January 16, 2018

**RE: Titan Presbyterian Hotel Block – Sector Plan Map Amendment and Site Plan for Building Permit
Project #1011099, 16EPC-40085/40087**

Conditions of Approval – 16EPC-40087– Sector Plan Map Amendment

Conditions of Approval – 16EPC-40085– Site Plan for Building Permit

SITE DETAILS

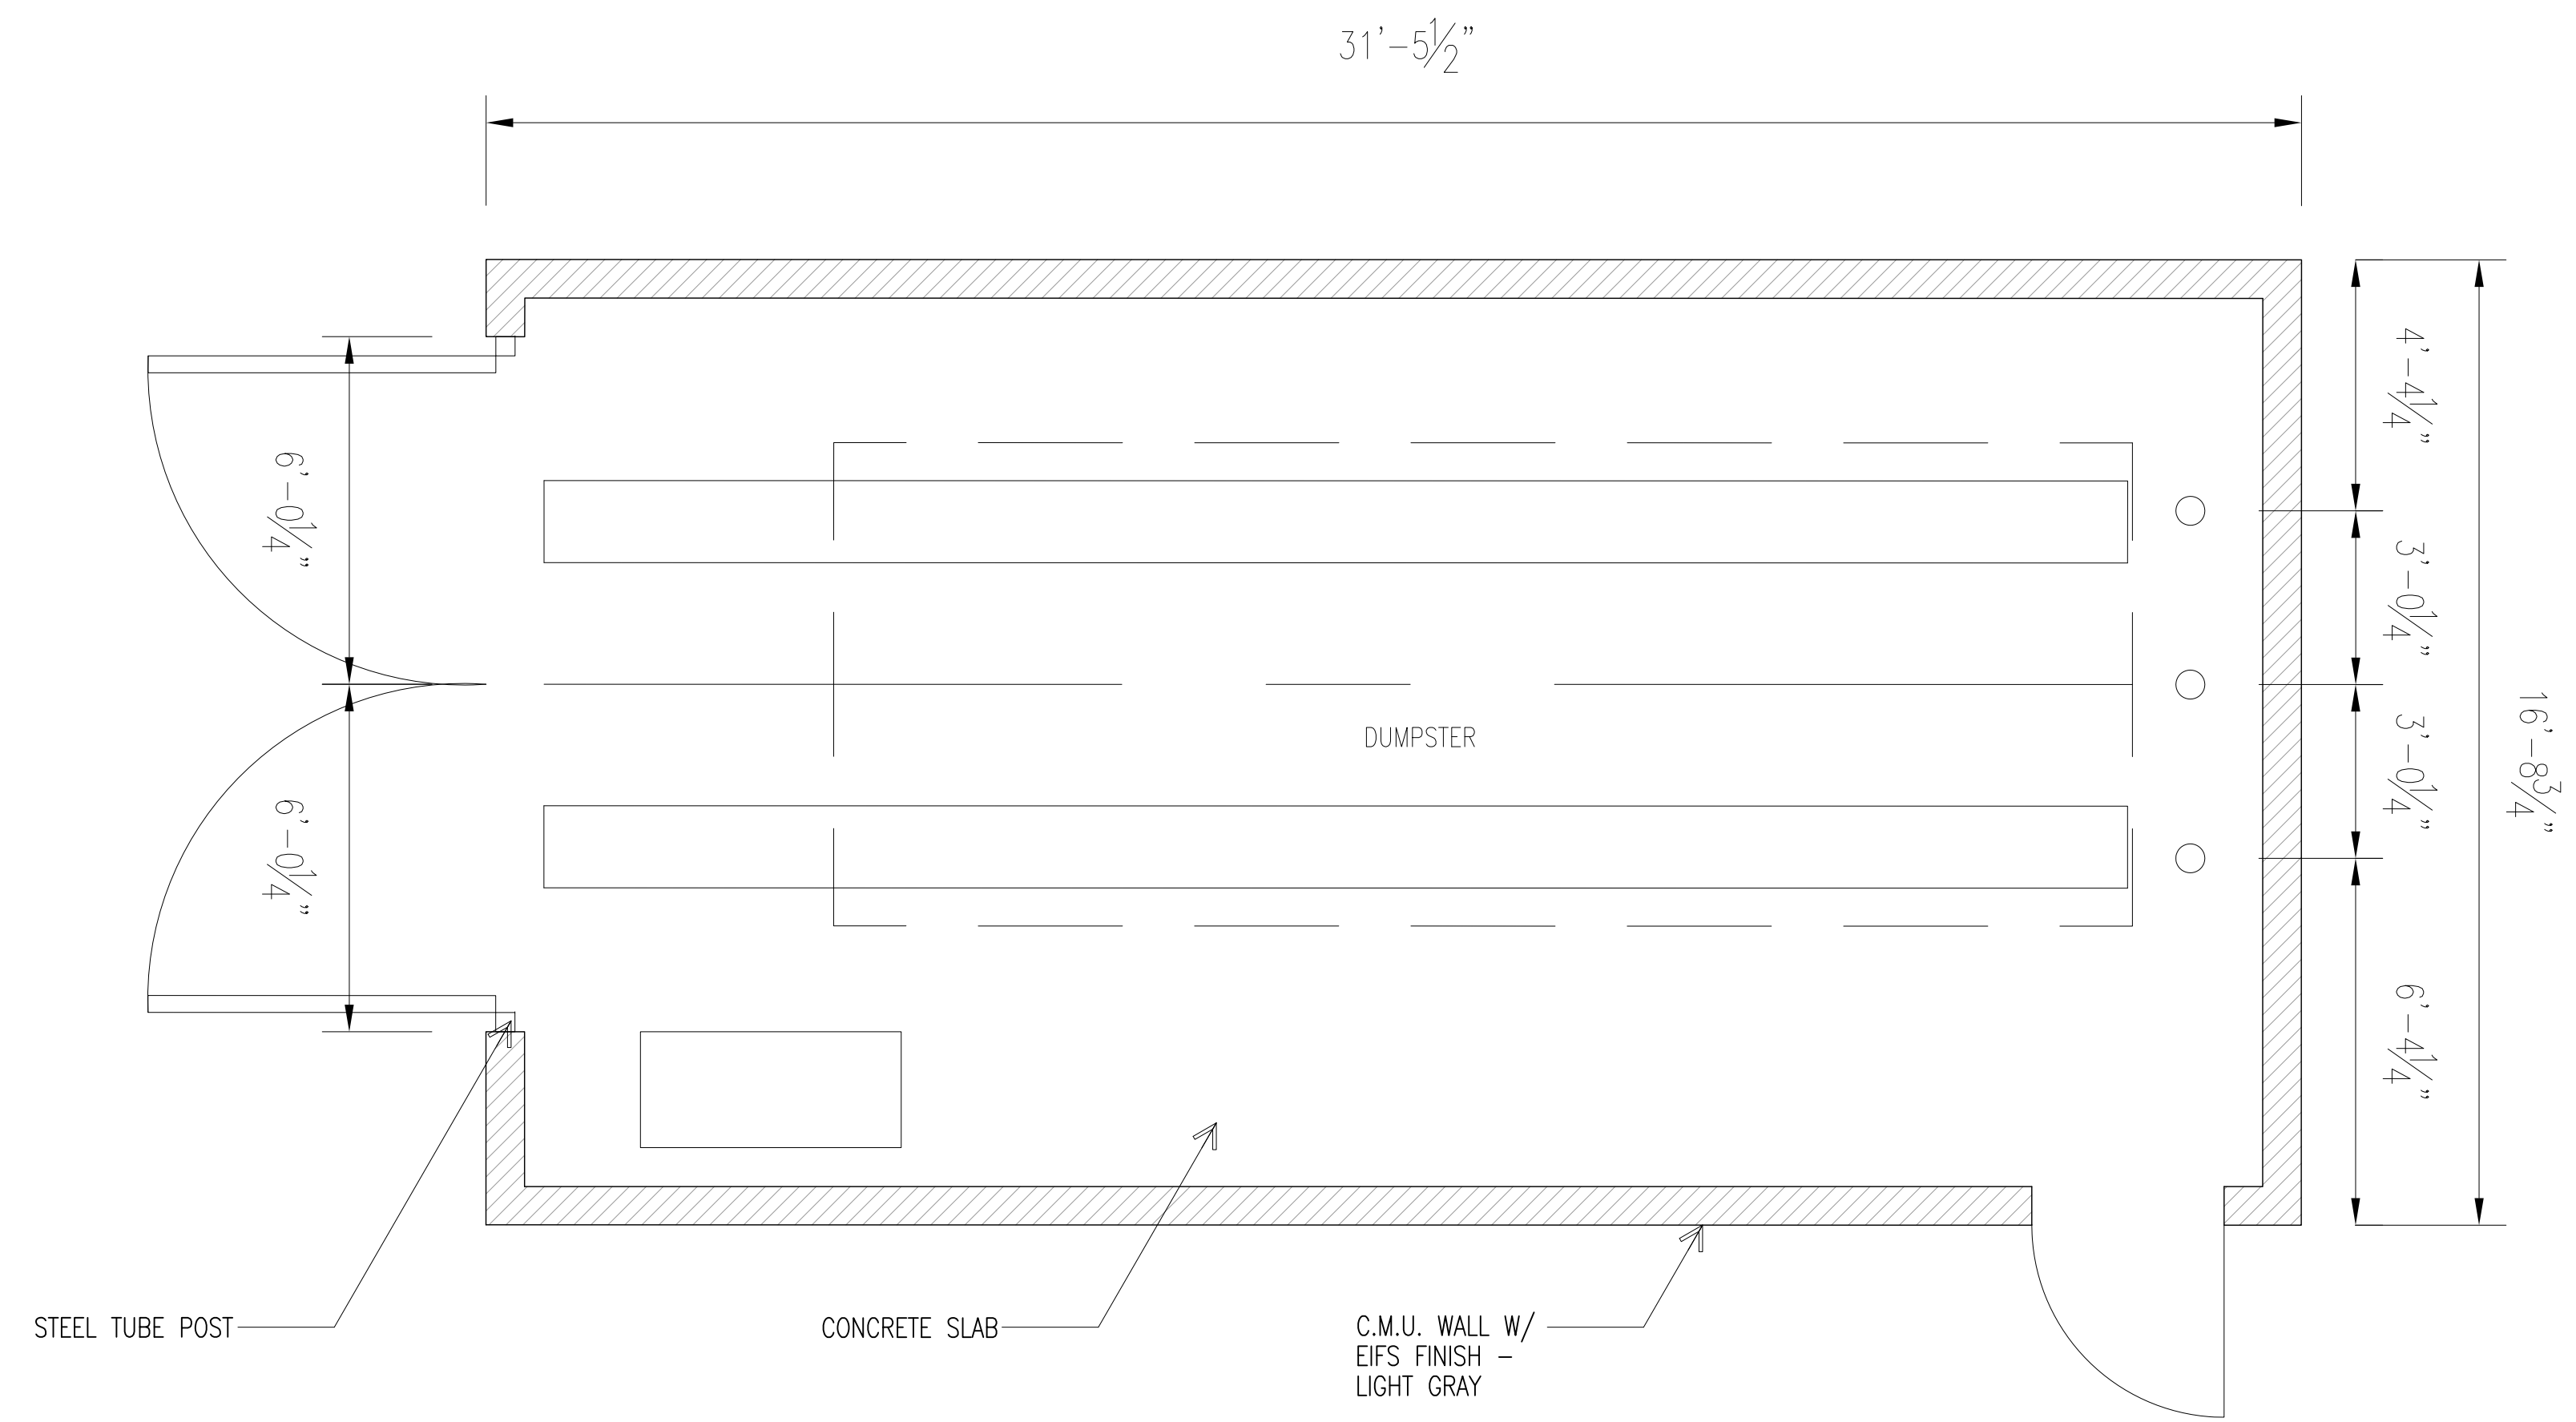
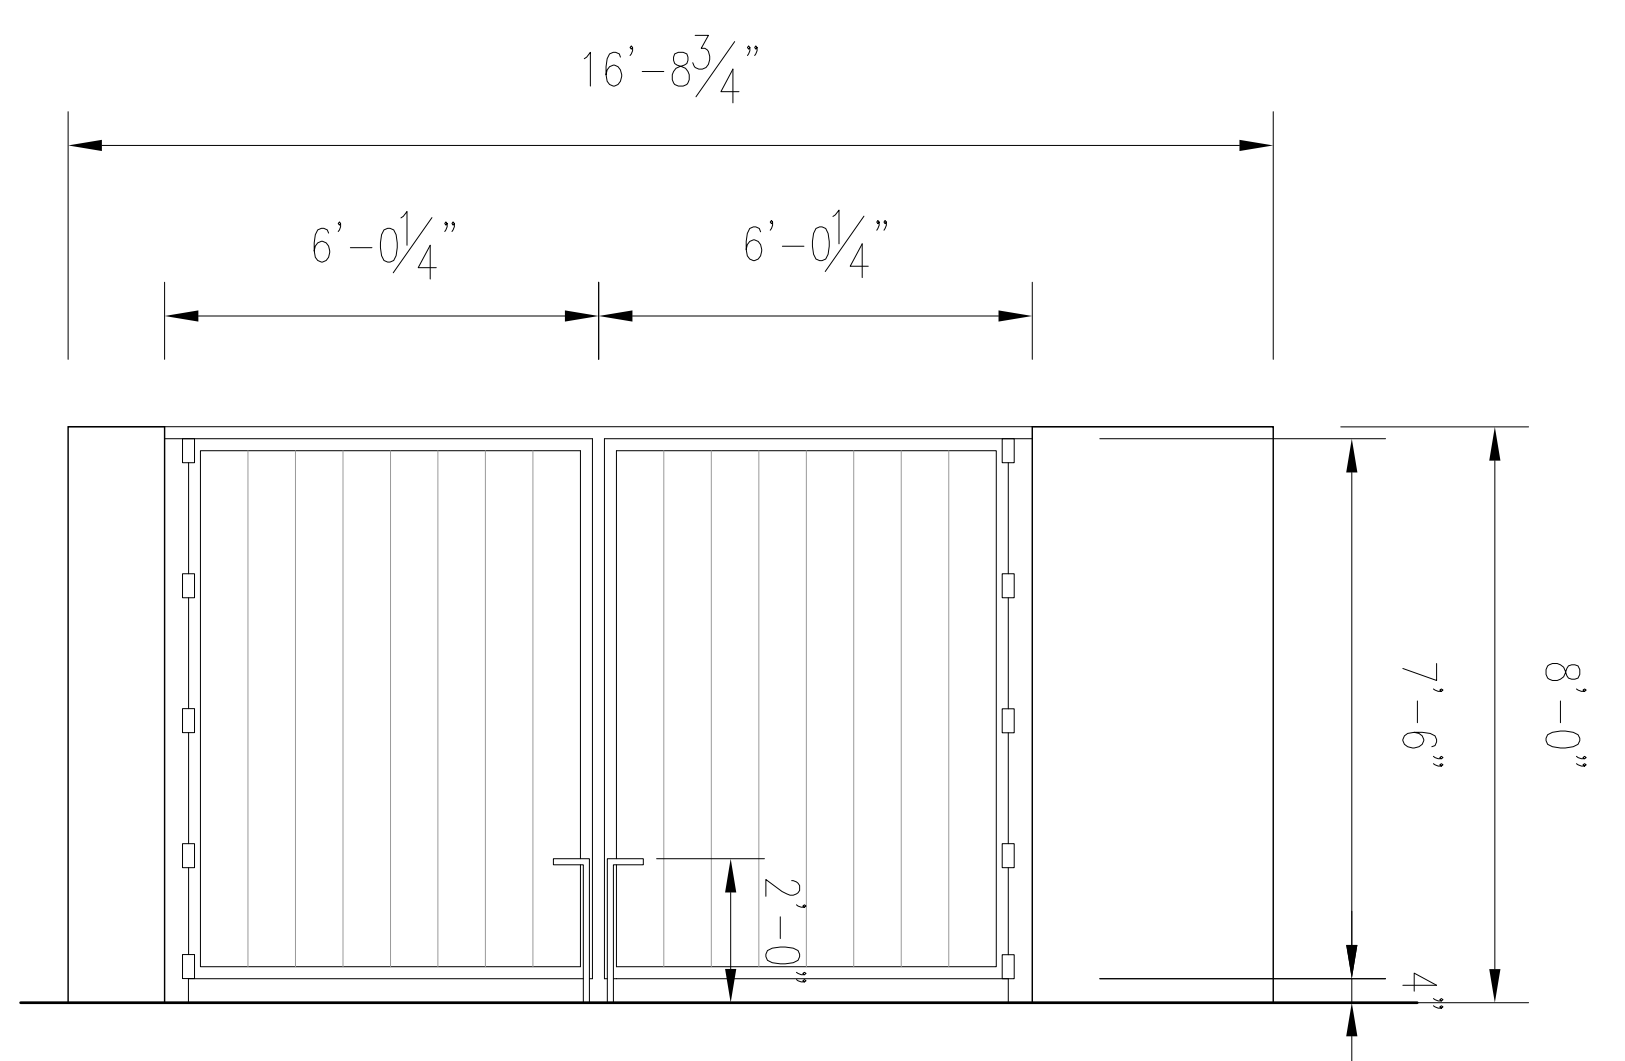
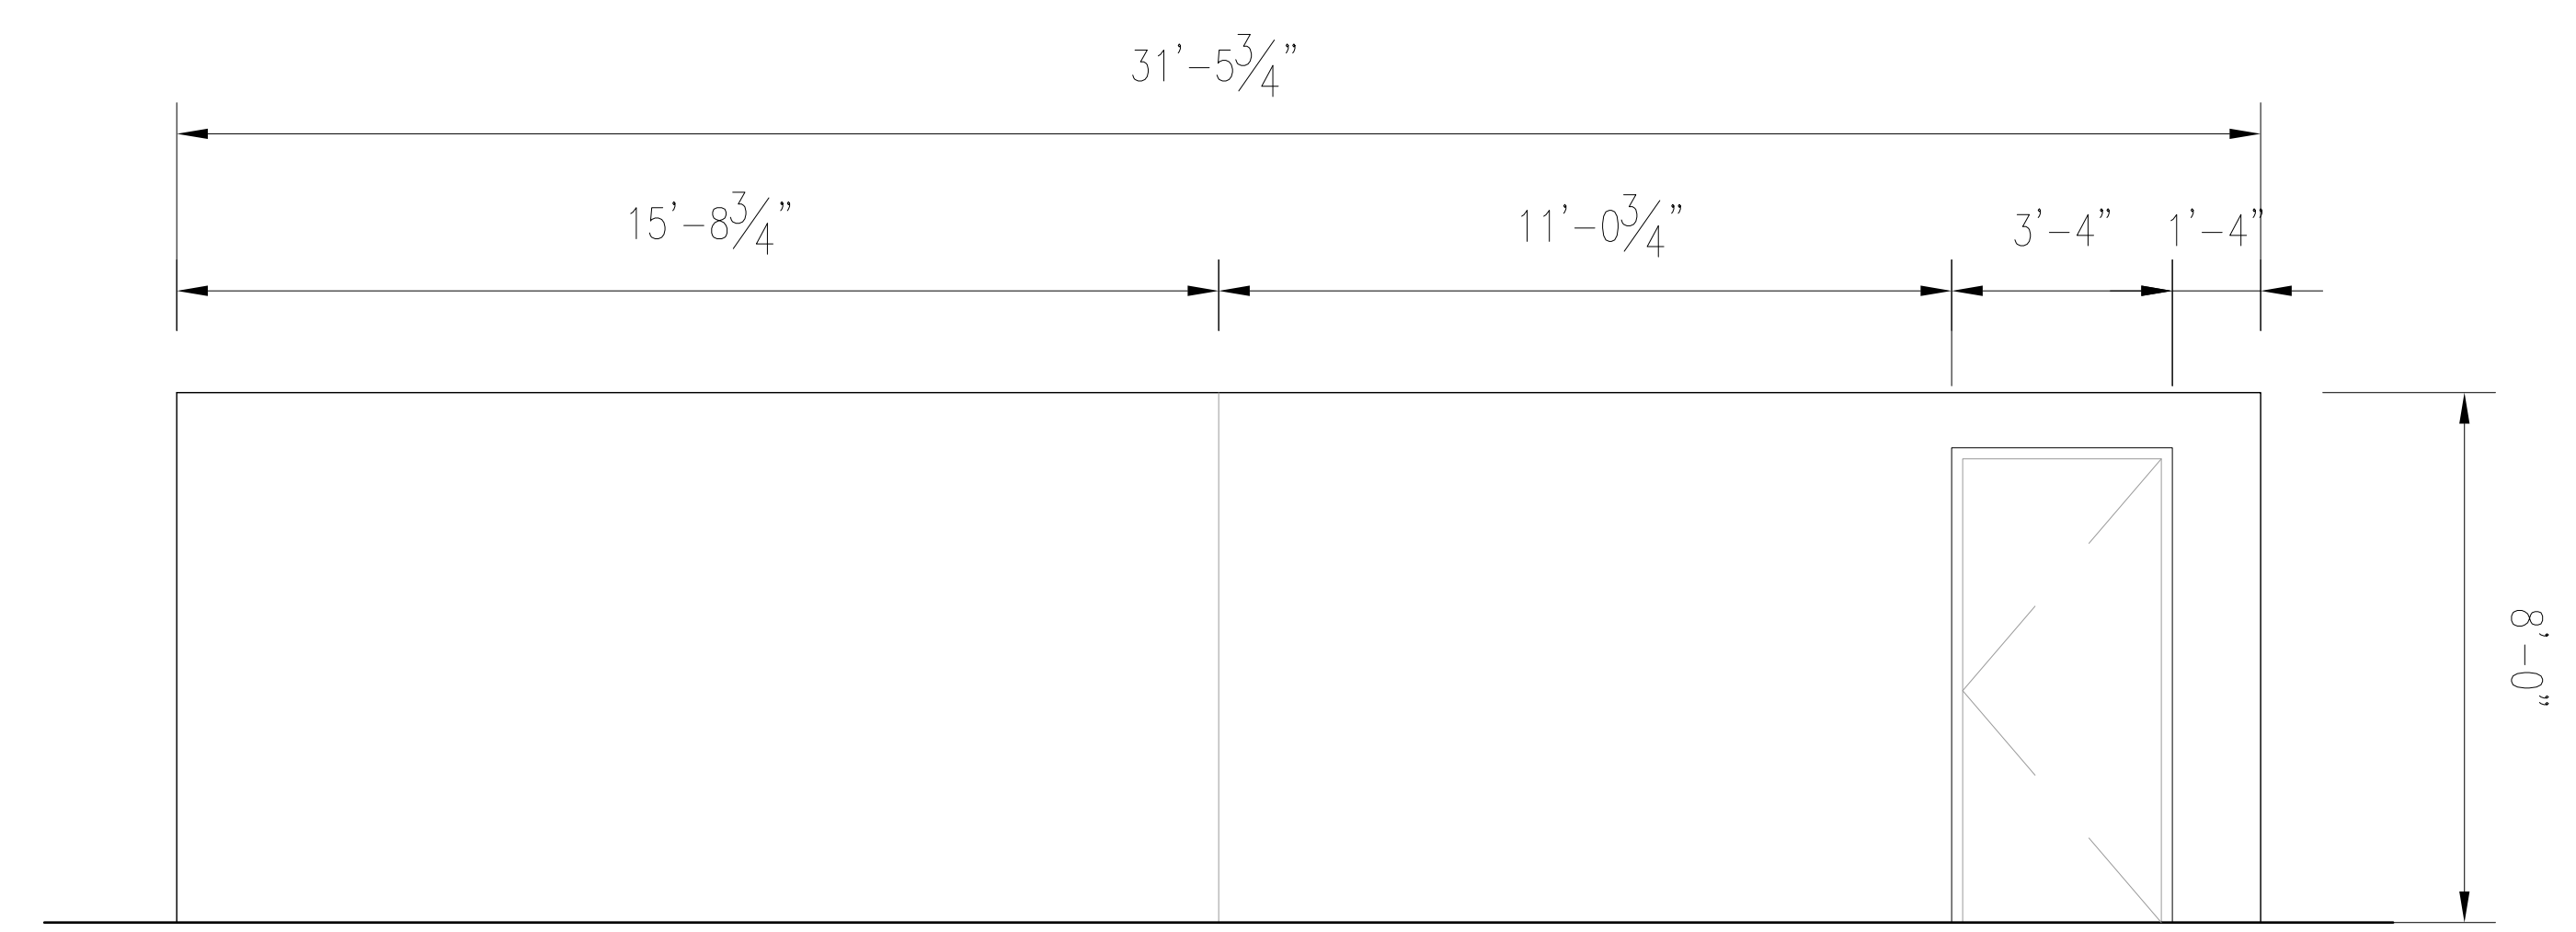
7. The site details sheet shall be updated to include more details on accessible parking spaces, signs, trash enclosure gate and wall details, accessible ramps, bicycle parking, and other information as necessary.

Site details sheets 8 and 9 have been updated to include additional details, as requested by this condition.
